August 17, 2022

**RE: Slim Chicken
8240 Montgomery Blvd NE
Grading and Drainage Plans
Engineer's Stamp Date: 08/02/22
Hydrology File: G19D004E**

RE: Slim Chicken
8240 Montgomery Blvd NE
Grading and Drainage Plans
Engineer's Stamp Date: 07/05/21
Hydrology File: G19D004E

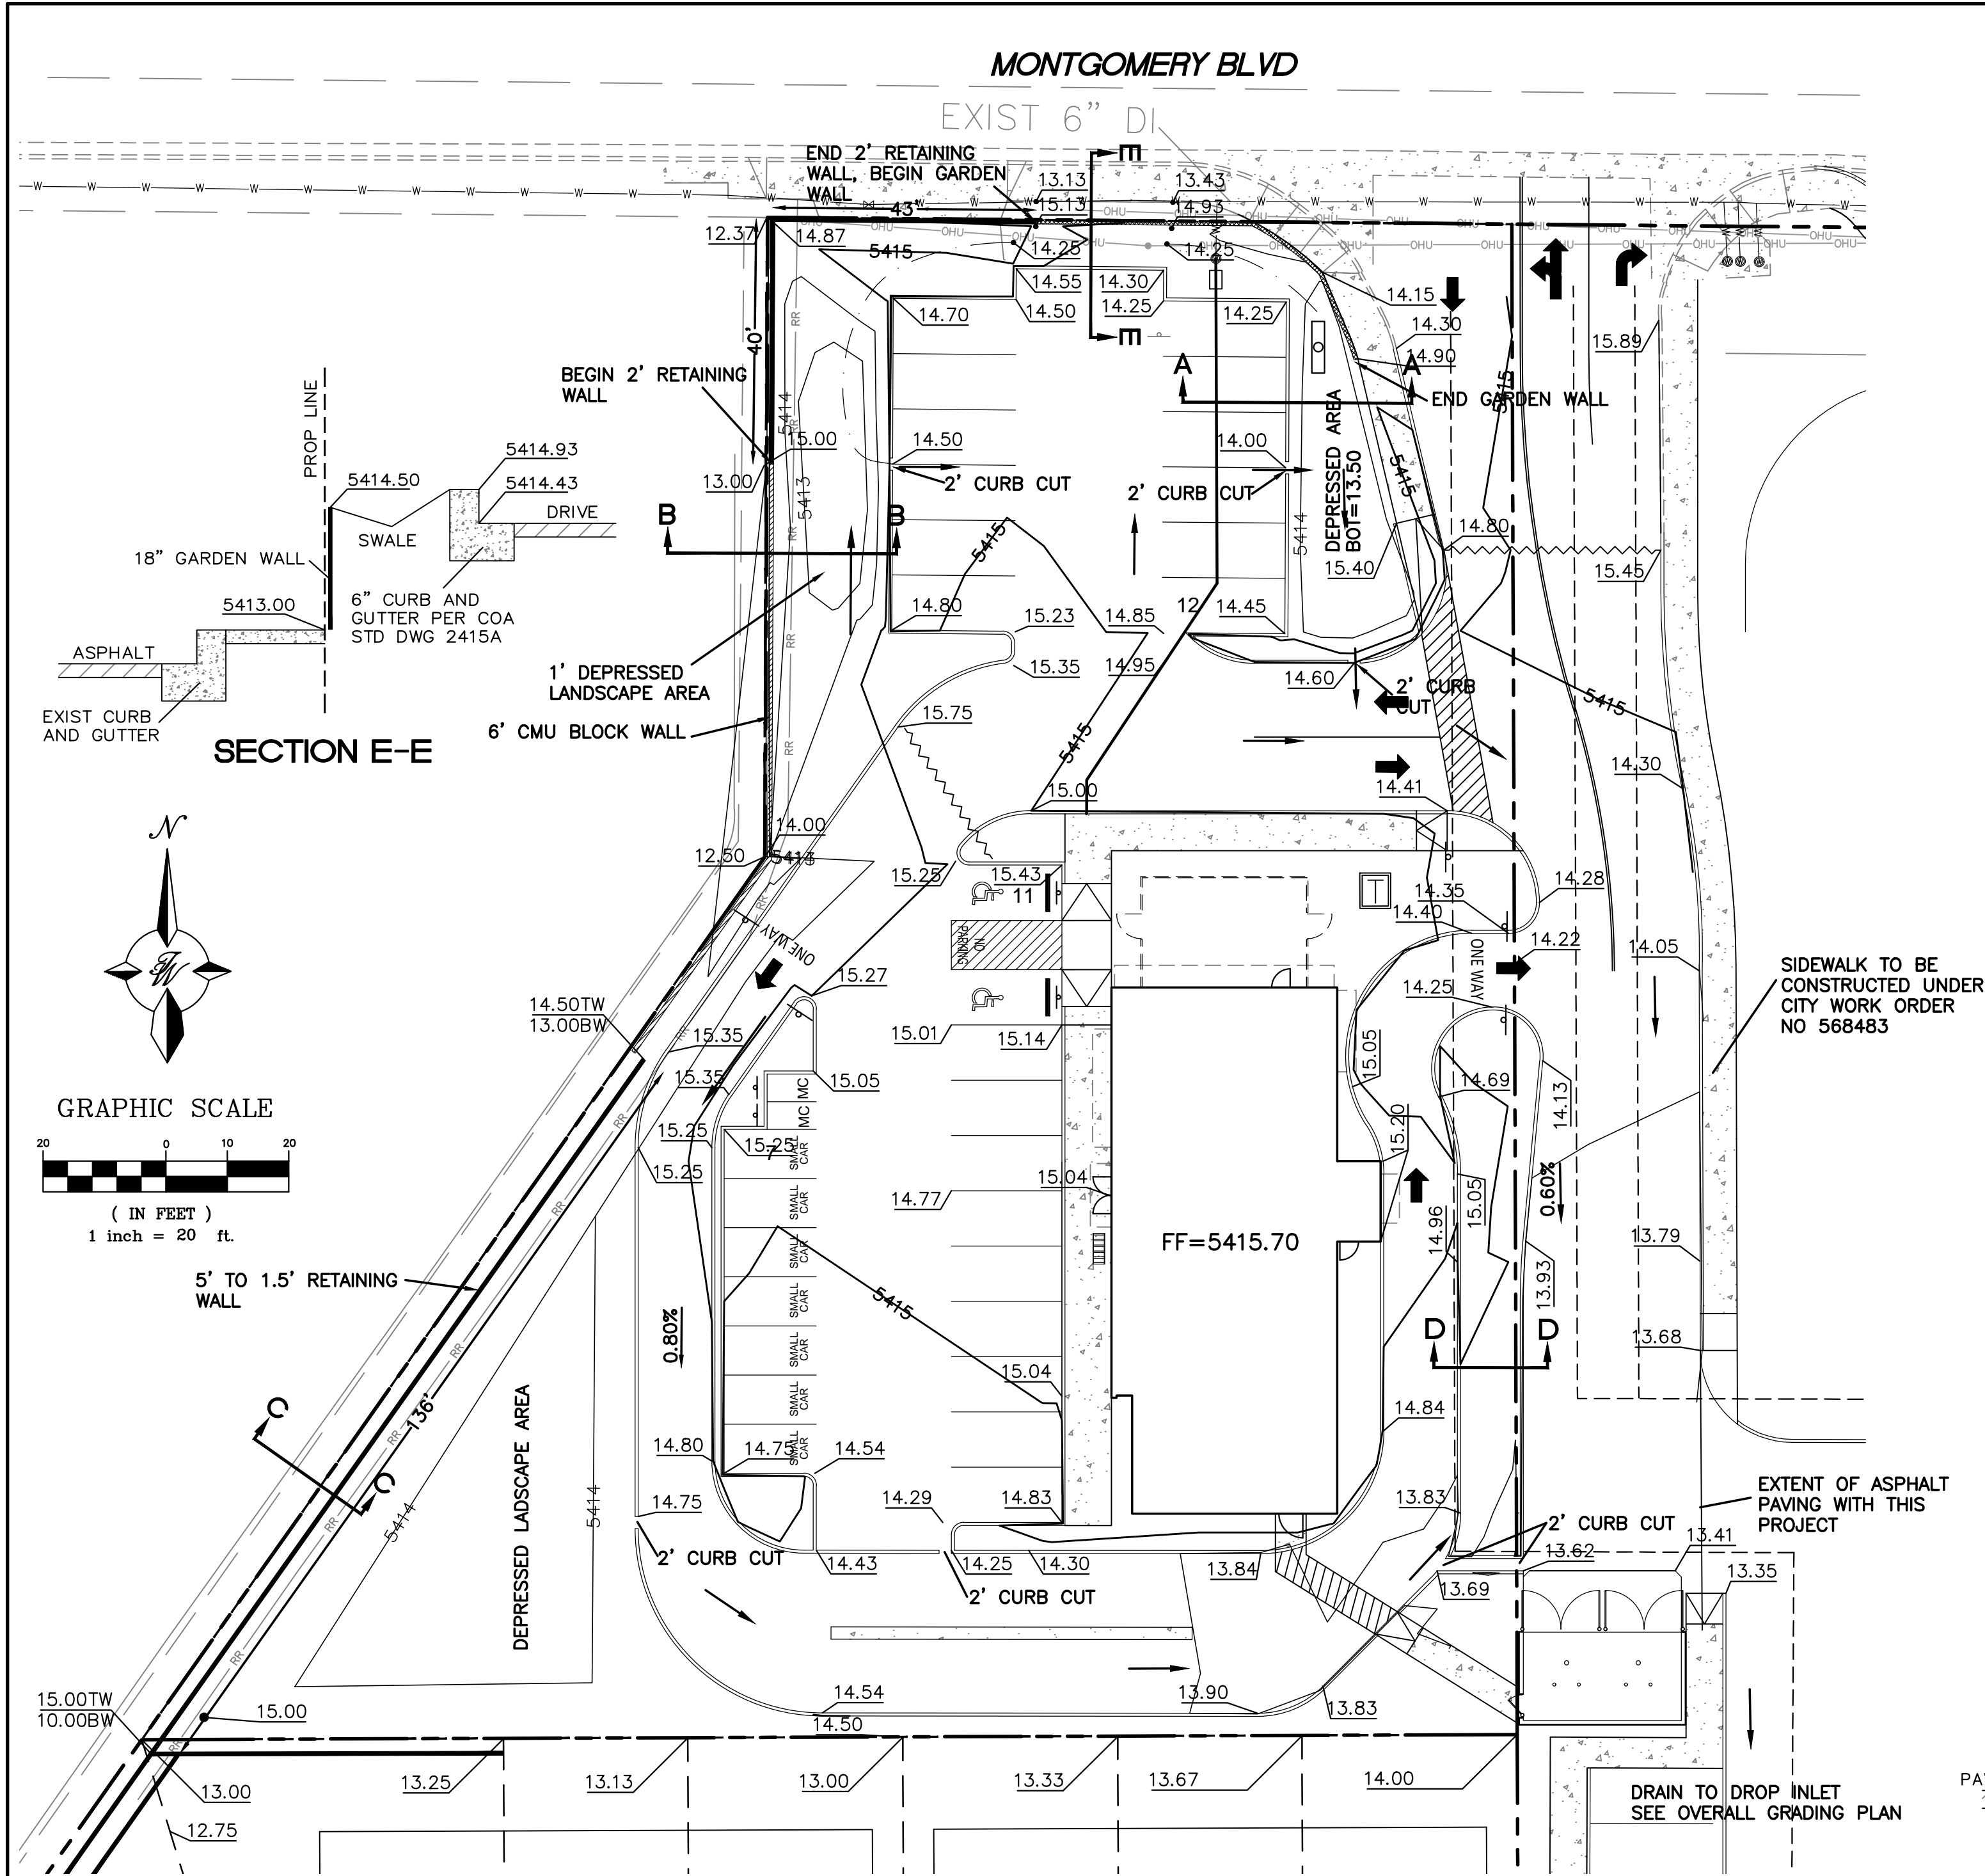
1. The retaining wall along Montgomery needs to be labeled as such in Section E-E. This also needs to show an L shaped footer within the property.

2. There is still issues with the whole parking area by Montgomery drainage. Where is this area discharging to? The two ponds don't appear to go anywhere and this will trap standing water & mosquitoes when it rains. This area may just drain over the block wall to the southwest and drain onto the adjacent property which is not allowed. Another

issue is that the depressed area of this Tract is covered by the overall development's Stormwater Quality Pond to the south next to La Mirada Place.

- Trash enclosures must demonstrate control of liquids from dumpster areas per DPM by containing runoff from the dumpster area, preventing outside drainage from entering the dumpster area, and discharging to the sanitary sewer. Please show an inlet in the middle and label. "Inlet to be connected to the sanitary sewer. See Utility Plan."

- The low area in the Southwest corner has some drainage issues. Where is this area discharging to? The pond doesn't appear to go anywhere and this will trap standing water & mosquitoes when it rains. This area may just drain to the residential development to the south which is not allowed. Again there is an issue is that the depressed area which is not needed since this Tract is covered by the overall development's Stormwater Quality Pond to the south next to La Mirada Place.

1. The retaining wall along Montgomery needs to be labeled as such in Section E-E. This also needs to show an L shaped footer within the property.
Garden walls are capable of supporting up to 18 inches of retainage before the need to be a retaining wall. The section was updated to show an L-shaped footing that does not encroach in the City right of way.

2. There is still issues with the whole parking area by Montgomery drainage. Where is this area discharging to? The two ponds don't appear to go anywhere and this will trap standing water and mosquitoes when it rains. This area may just drain over the block wall to the southwest and drain onto the adjacent property which is not allowed. Another issue is that the depressed area which is not needed since this Tract is covered by the overall development's Stormwater Quality Pond to the south next to La Mirada Place.
As stating in the Proposed Drainage Narrative and in the previous response letters these areas are passive water harvesting areas that overflow through 2' wide curb cuts. All drainage flows to the southeast corner of the property per the Overall Drainage Plan and drain to a drop inlet near the residential neighborhood. We had previously place flow arrows on the plan showing direction of flow and how these depressed landscaped areas drain through the curb openings. We have no added a note to each areas stating that these depressed landscaped areas overflow through the 2' curb openings. The only storm water that is in these areas is what falls on it and will either infiltrate the ground or evaporate prior to the gestation period of mosquitoes.

3. Trash enclosures must demonstrate control of liquids from dumpster areas per DPM by containing runoff from the dumpster area, preventing outside drainage from entering the dumpster area, and discharging to the sanitary sewer. Please show an inlet in the middle and label. "Inlet to be connected to the sanitary sewer. See Utility Plan."
The trash enclosure has drains connected to a grease interceptor that drains to the sanitary sewer. A note was added to the grading plan stating as much.

4. The low area in the Southwest corner has some drainage issues. Where is this area discharging to? The pond doesn't appear to go anywhere and this will trap standing water and mosquitoes when it rains. This area may just drain to the residential development to the south which is not allowed. Again there is an issue is that the depressed area which is not needed

As stating in the Proposed Drainage Narrative and in the previous response letters these areas are passive water harvesting areas that overflow through 2' wide curb cuts. All drainage flows to the southeast corner of the property per the Overall Drainage Plan and drain to a drop inlet near the residential neighborhood. We had previously place flow arrows on the plan showing direction of flow and how these depressed landscaped areas drain through the curb openings. We have no added a note to each areas stating that these depressed landscaped areas overflow through the 2' curb openings. The only storm water that is in these areas is what falls on it and will either infiltrate the ground or evaporate prior to the gestation period of mosquitoes. There is also a CMU block wall along the west property line that will prevent any flows from entering or existing this parcel from/to the residential development to the west.
